STATE OF WASHINGTON
DEPARTMENT OF ECOLOGY

Re: SEPA Register 202101165, CU-21-00002

Thank you for the opportunity to comment during the Optional Determination of Non Significance process for the Sweetwater Ranch Event Facility. Washington State Department of Ecology (Ecology) has reviewed the documents and has the following comments.

REVISED SITE PLAN
DATED 11-16-21

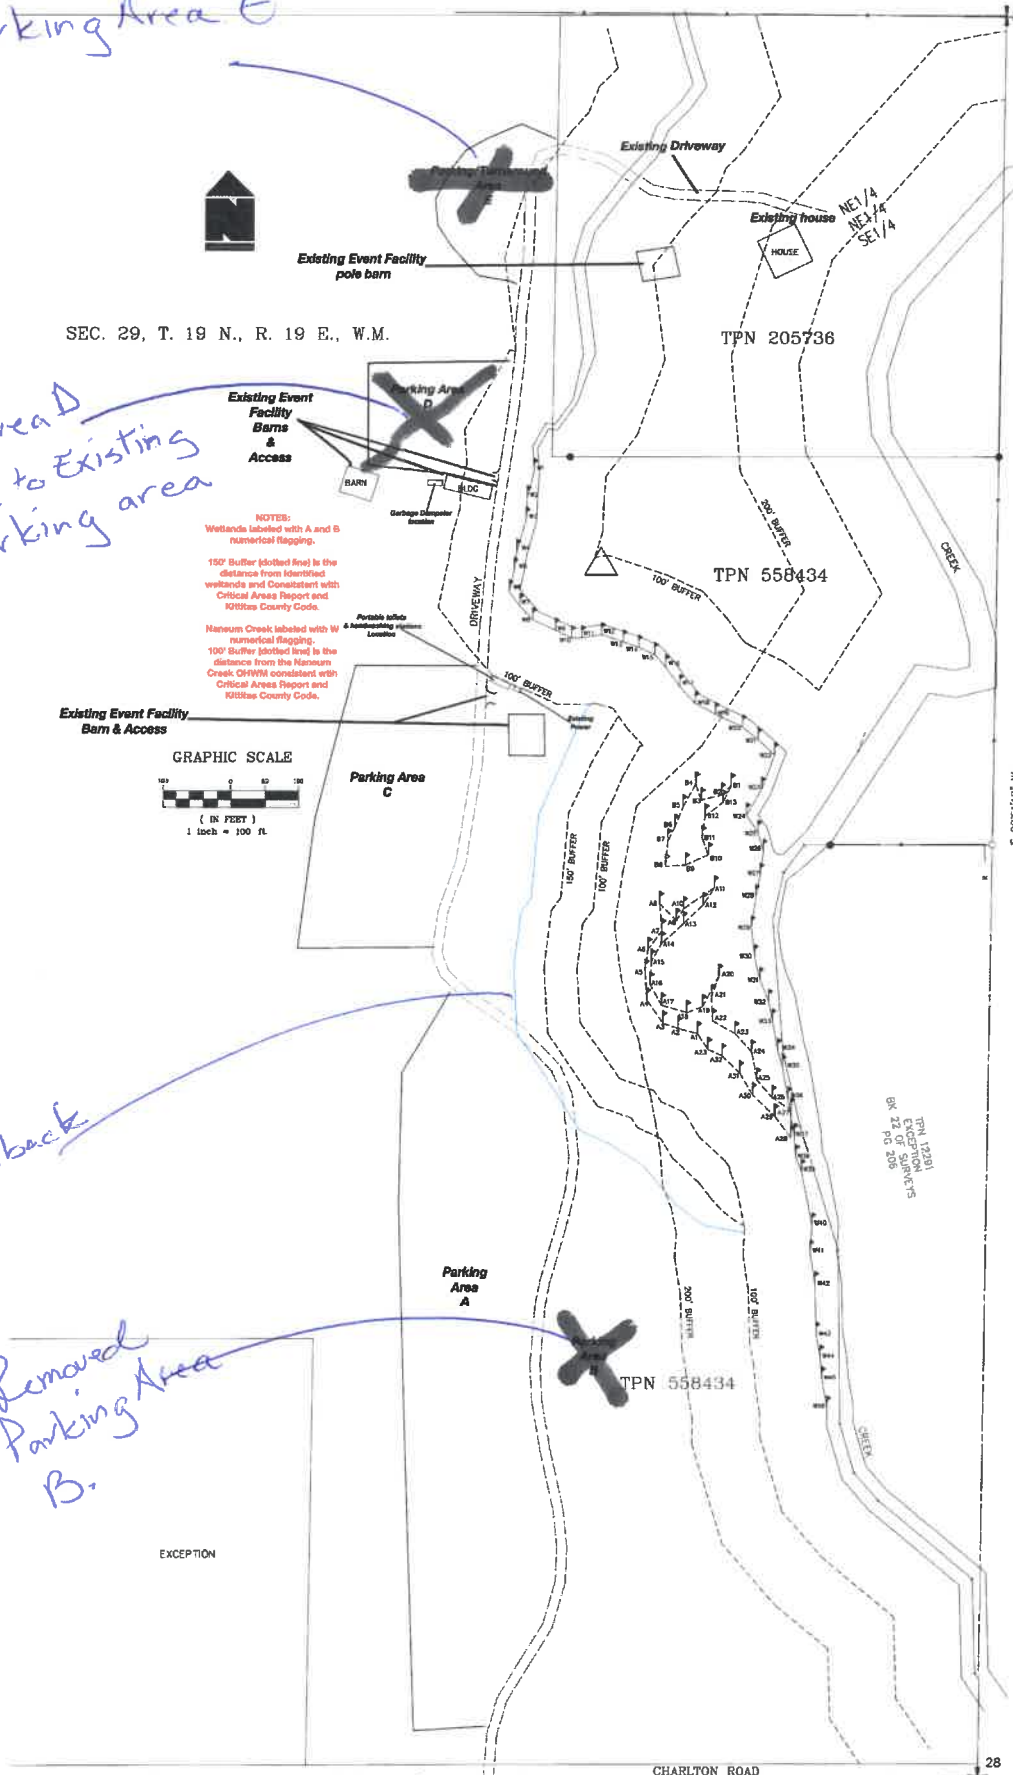
Upon conducting a desk review of the project area, reviewing the Critical Areas Report by Sewall Wetland Consulting Inc., and the site plan Ecology staff have some concerns with the proposed location of Parking Area B.

# SITE PLAN

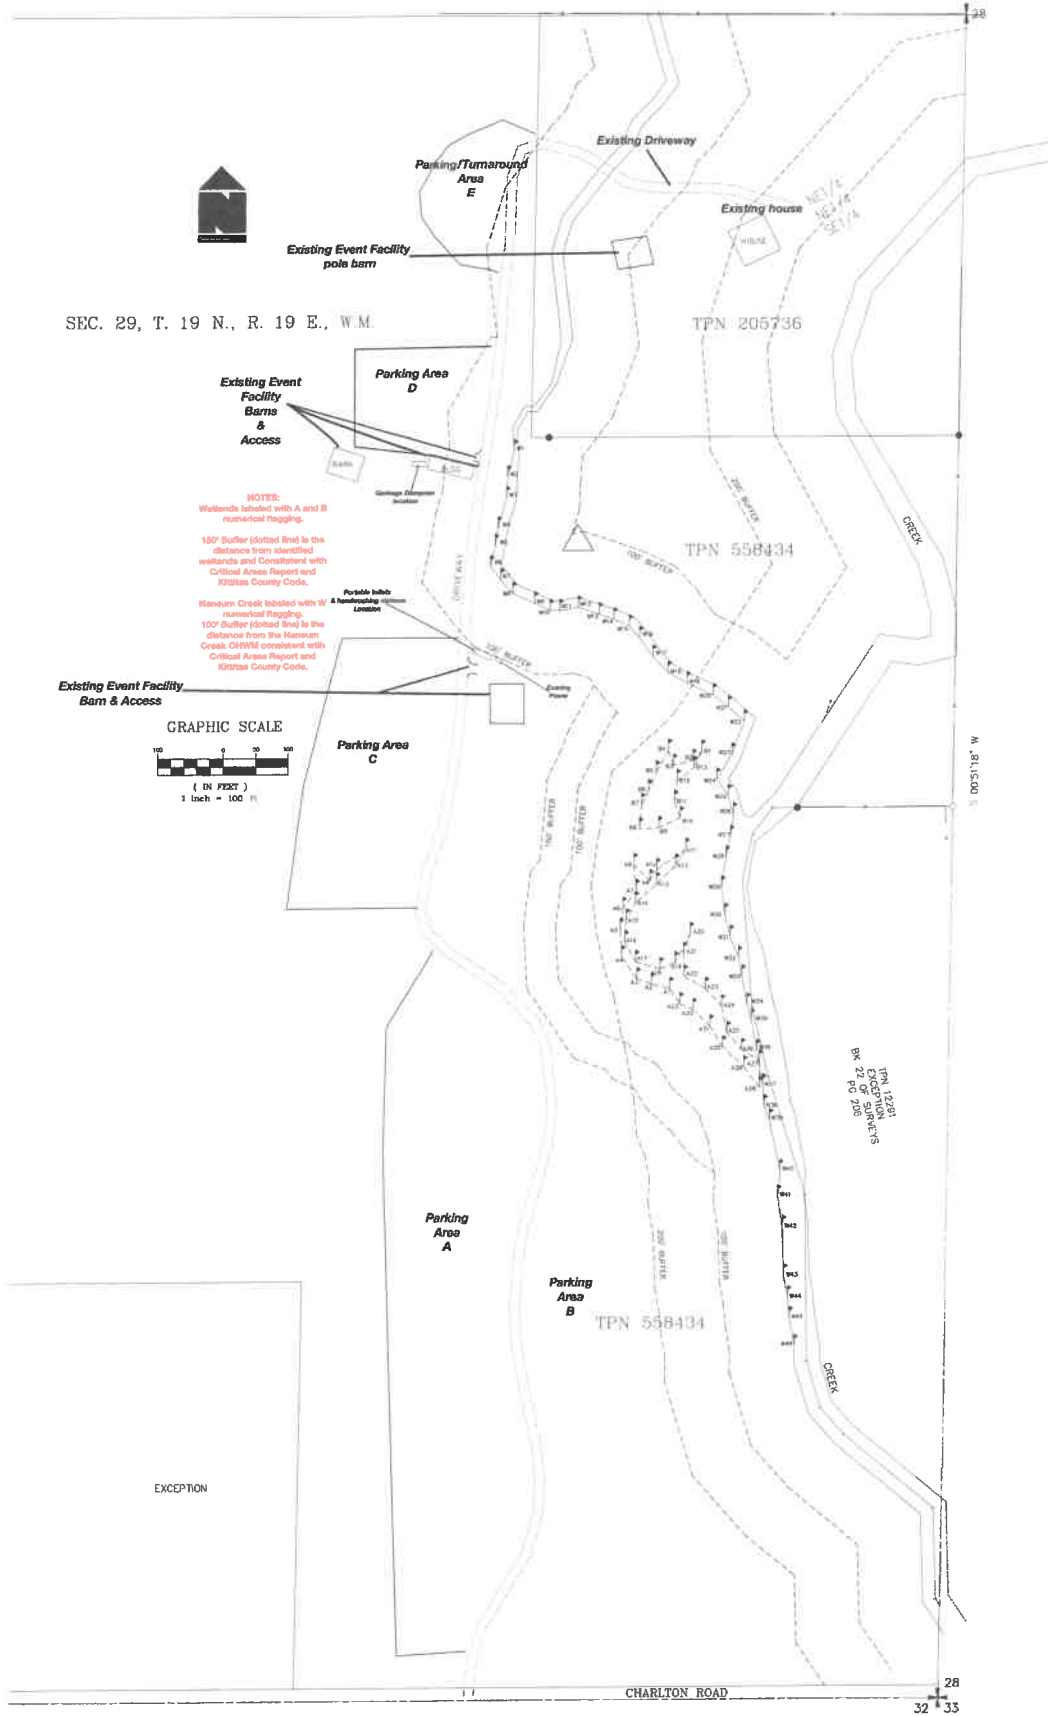
Ecology staff noted the wetland delineation was conducted outside the growing season, in November 2019, and the precipitation preceding the site investigation was not provided. Several areas of concern were observed on current and historical aerial imagery. Ecology would like to request a joint site visit to investigate the areas of concern and confirm the wetland boundary.

In addition, to the areas of interest and requested site visit, Ecology requests the County revisit the required wetland buffer for Category II associated wetlands under the Shoreline Master Program (SMP). The wetlands located on the parcel would be regulated under the Counties Shoreline Master Program (SMP). Per table 5.2-1, Wetland Buffers for Wetlands in Shoreline Jurisdiction, Category II wetlands in an area of high landuse intensity require a 200 foot wide buffer to properly protect the high functioning wetland. An event center with multiple parking needs, pedestrian foot traffic, etc. would be considered to be high intensity landuse and not low or moderate.
